**From:** Holly Duncan  
**Sent:** Thursday, January 10, 2013 3:38 PM  
**To:** Jeff Watson  
**Subject:** RE: BL-12-00035 City of Cle Elum

**From:** Jeff Watson  
**Sent:** Tuesday, January 08, 2013 5:03 PM  
**To:** Christina Wollman; Brenda Larsen; Jan Ollivier; Holly Duncan  
**Subject:** BL-12-00035 City of Cle Elum

**BOUNDARY LINE ADJUSTMENT**  
 PREPARED FOR  
 CITY OF CLE ELUM  
 A PORTION OF SECTION 4,  
 TOWNSHIP 19 NORTH, RANGE 15 EAST, W.M.

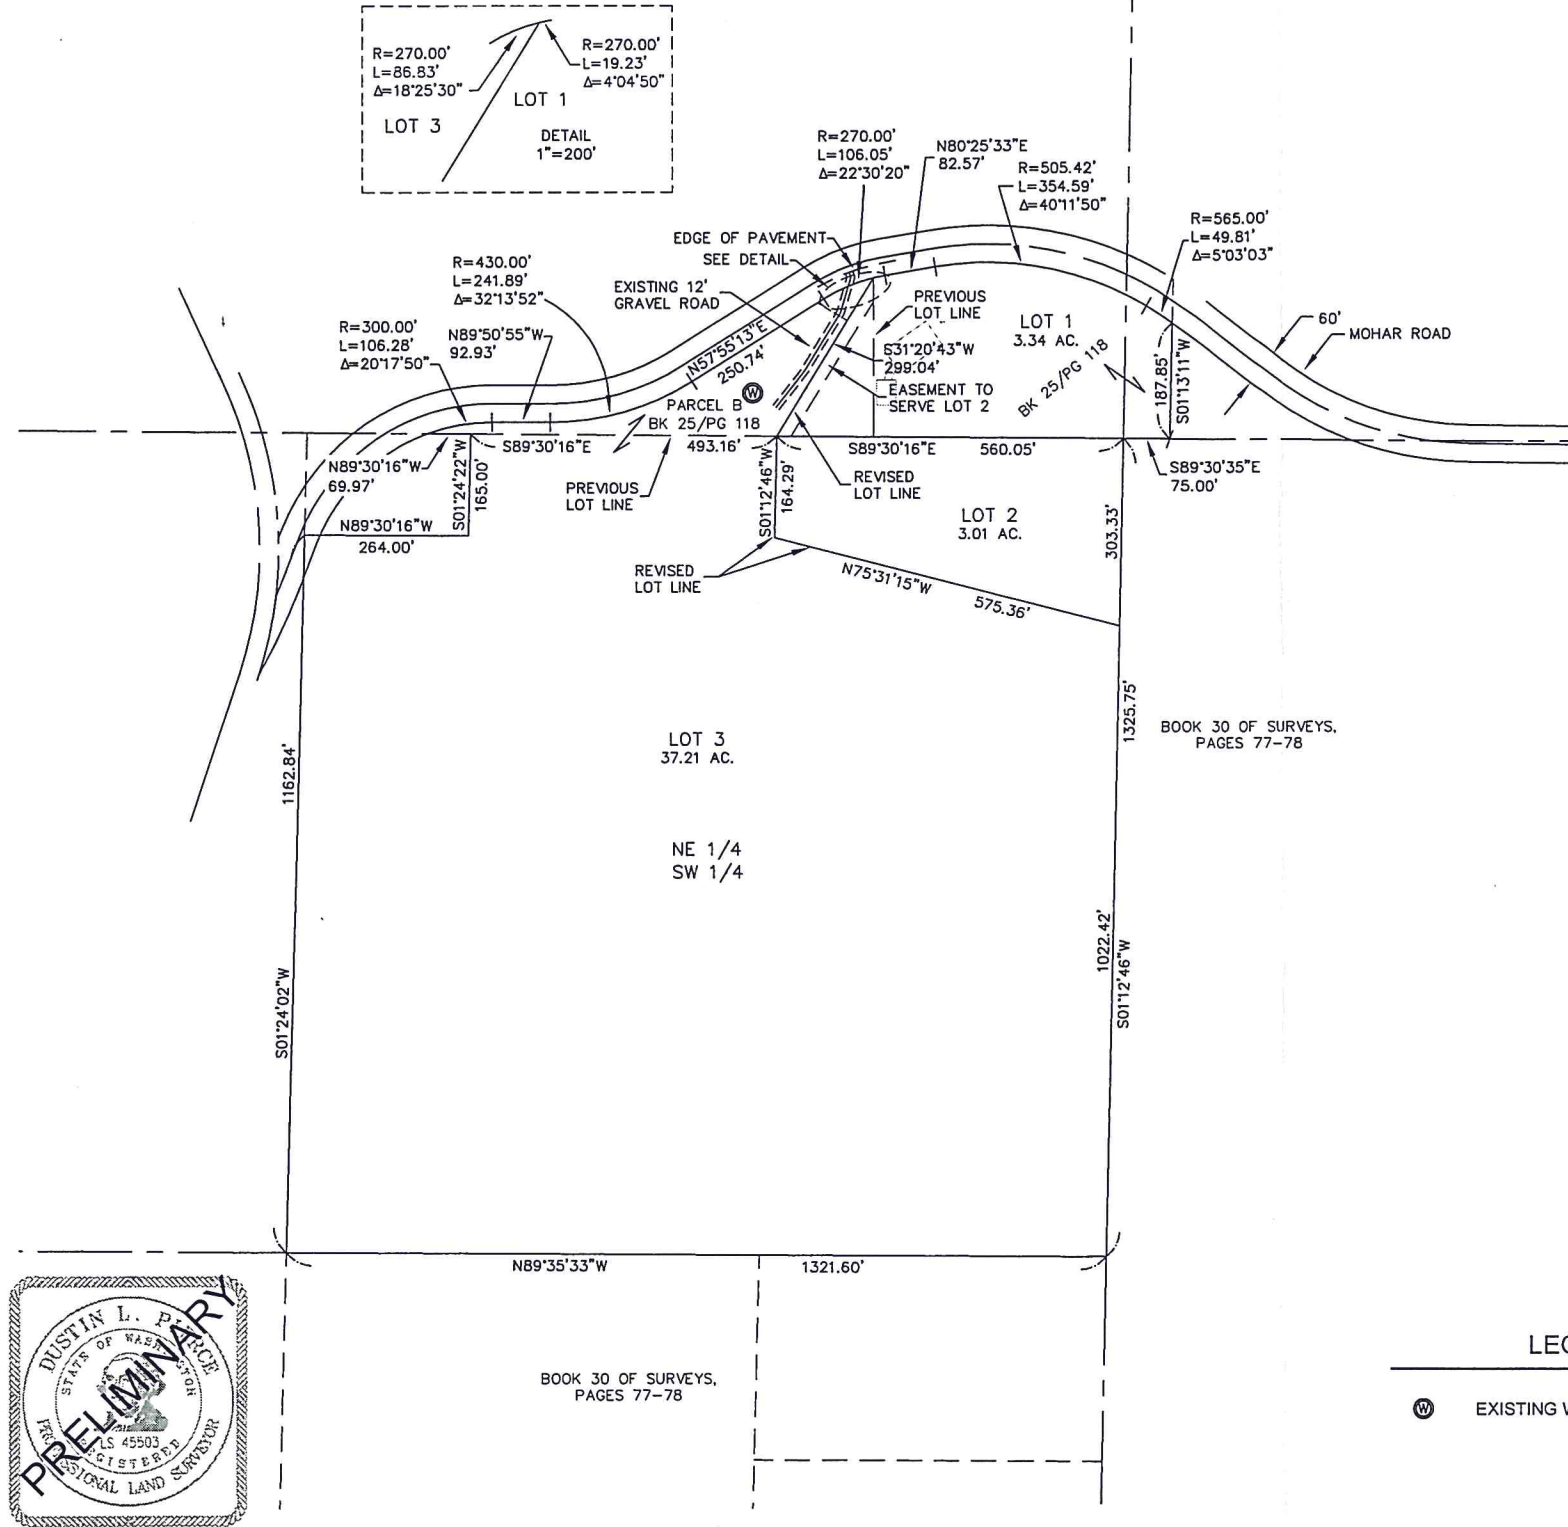
This looks fine. The proposed property line close to the existing well appears to be 50 feet away. I don't see any other issues with the other proposed lines.
